# **A303 Sparkford to Ilchester Dualling**

## **Project TR010036**

### **Deadline 4**

### **Summary**

Figure 2.2 Main site compound.

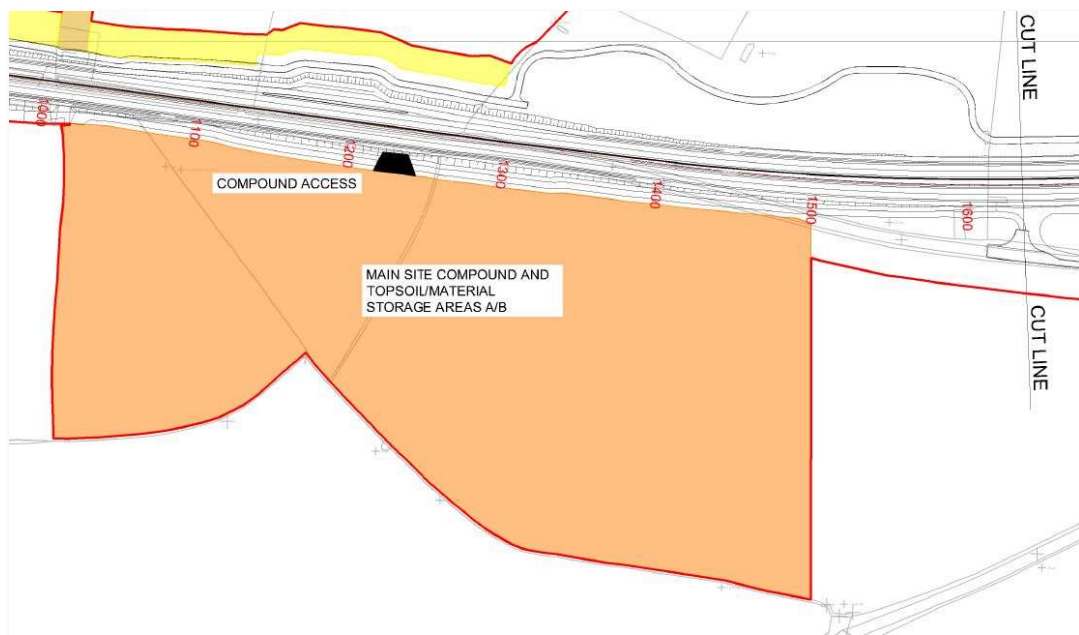
The material change required here is for the relocation of the Compound previously between the existing A303 and the B3151 and now to be further west against the south side of the existing A303. It is still a source of wonderment that the main accommodation, material and plant storage area would be sited on the land which is at the south side of the existing highway which will continue to be fully used for a large part of the programme period and more importantly is totally disconnected to the area of primary construction (see AKT 7 attached). APP-005 drawing DR-UU-2018 shows Work No 10 within the existing DCO red boundary line. Work No 10 is at the correct side of the majority of construction operations and can readily be serviced by vehicles carrying substantial quantities of aggregates and tarmac approaching on the eastbound carriageway from the A37 the main source of supply of such materials. If area Work No 10 is not available, then it is suggested that other locations adjacent should be investigated.
